PLAN EXAMINATION CONDITIONAL APPROVAL

Canal Landing

100 West Commercial Street – Portland, Maine

Review Type:	Bldg & Structural
Plans Date:	1/3/2019
# of Sheets:	75
Project Area (sq. ft.):	30,148

SHEET:
4A

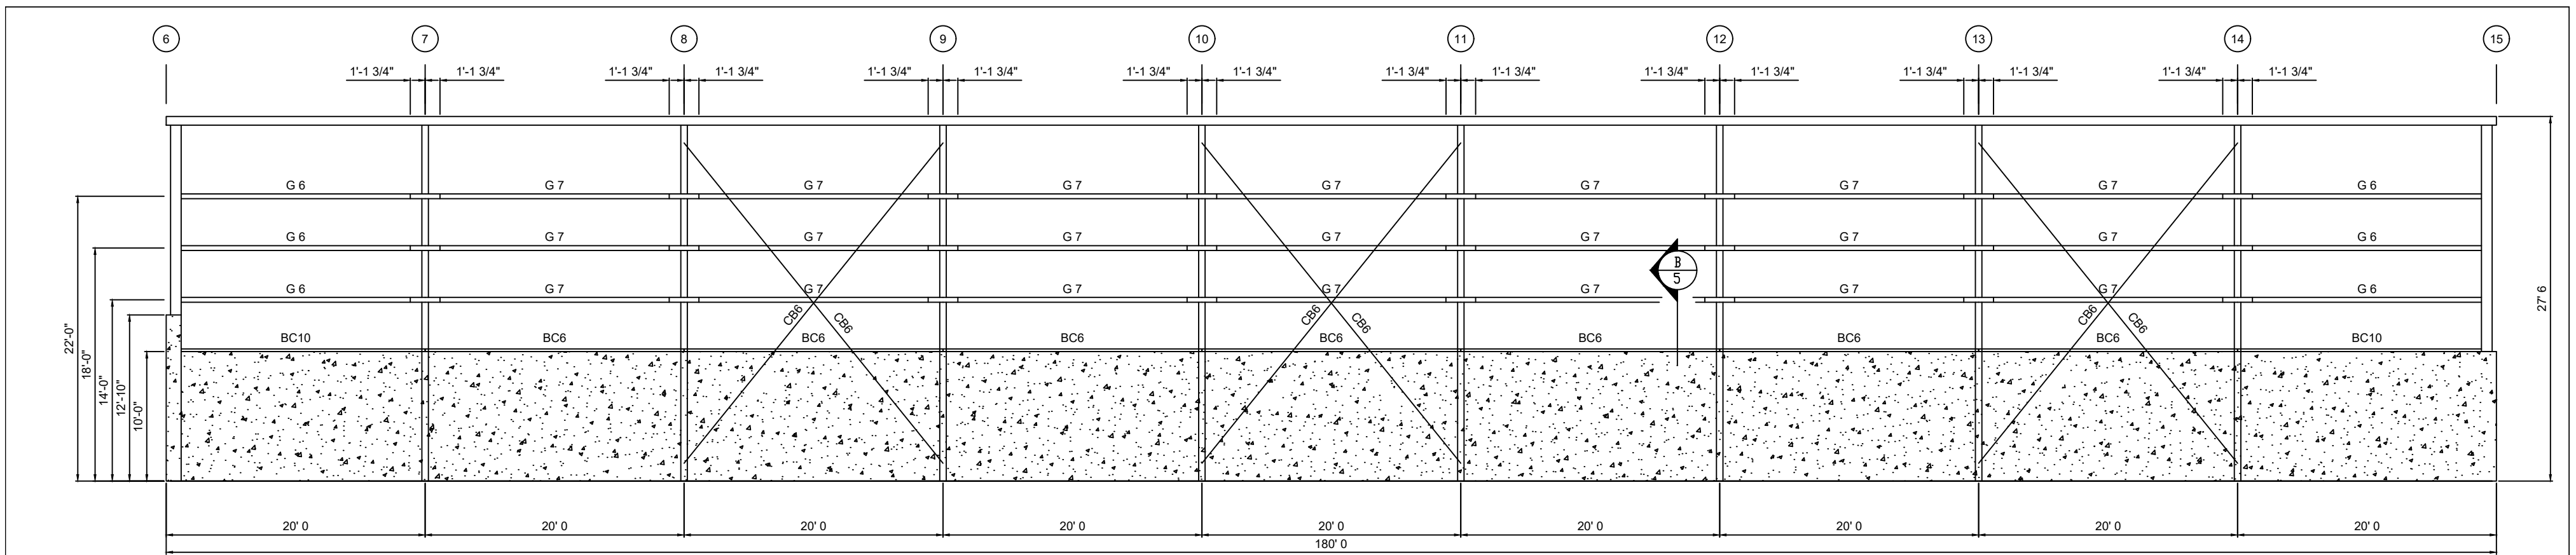
2. Purlins are to be braced against rolling and anchorage is to be provided at the purlin to frame connection.
3. Page 4A detail B/4A (Gable) and C/4A (Single Slope) has a 2" x 2" x 14 ga angle for bottom flange purlin bracing. The axial force in the angle is to be resolved to the framing.

1 | WALL SECTION AT GRIDLINE A
1/2" = 1'-0"

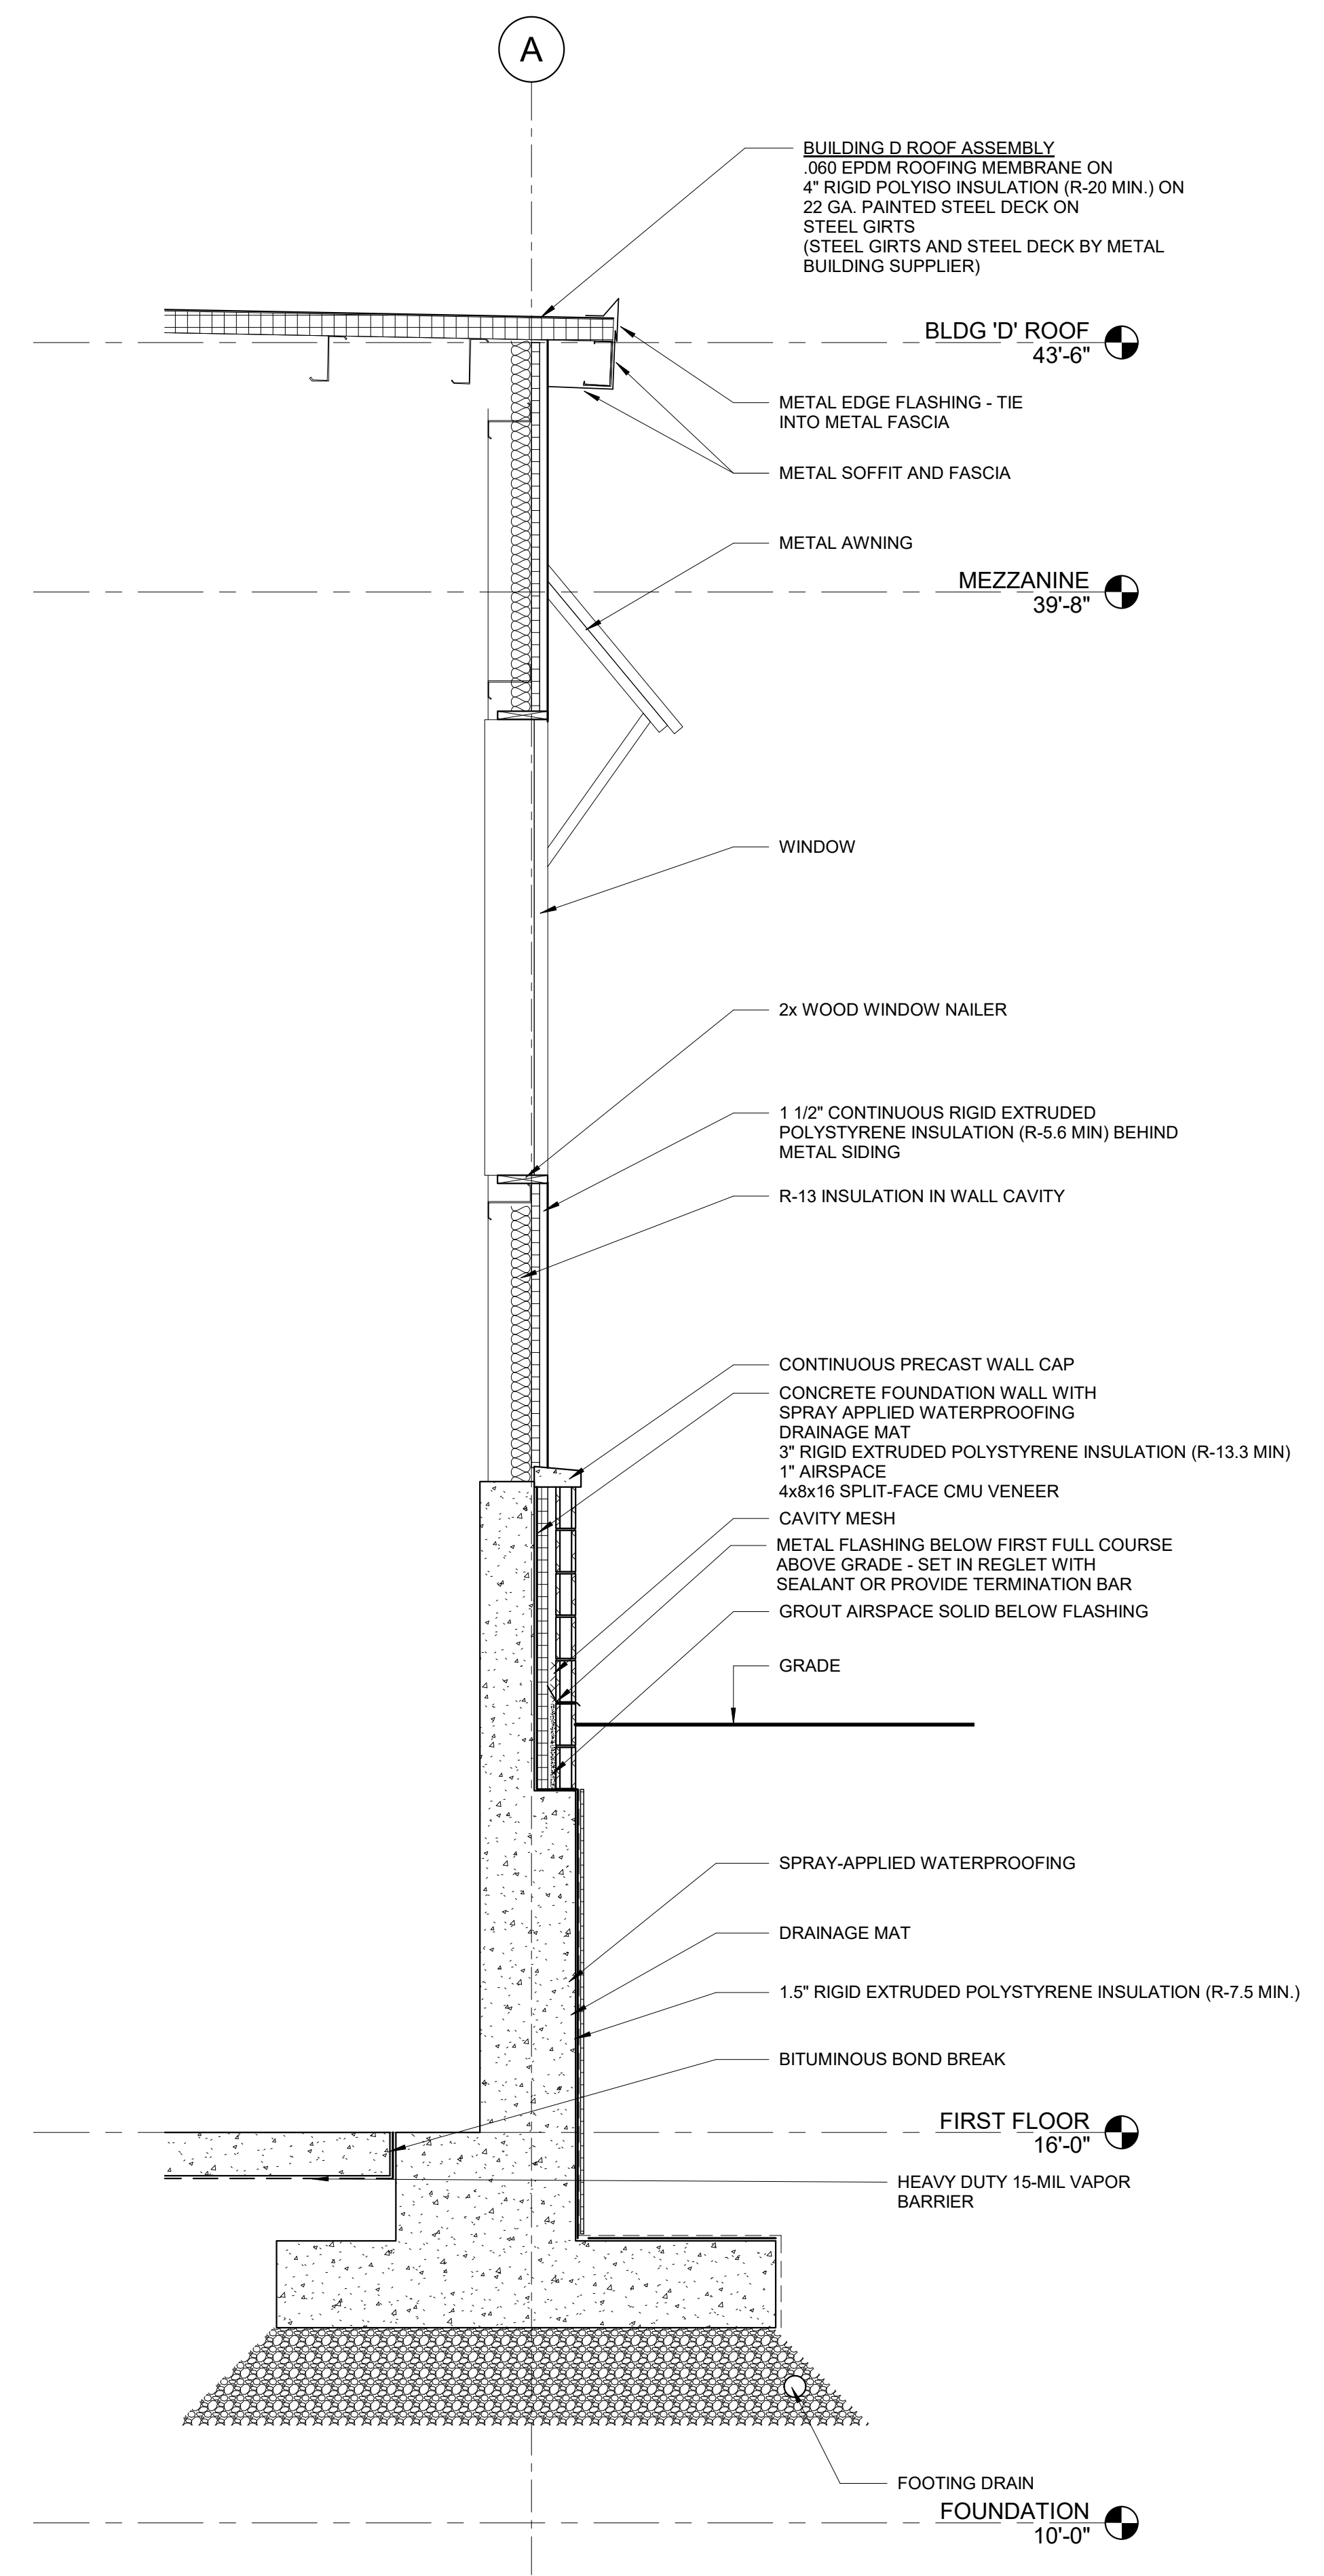
1. Exposed steel (including the columns at Line A.1) is to be protected against corrosion in accordance with AISC 360 Section B.13 as indicated in IBC 2015 Section 2203.2.
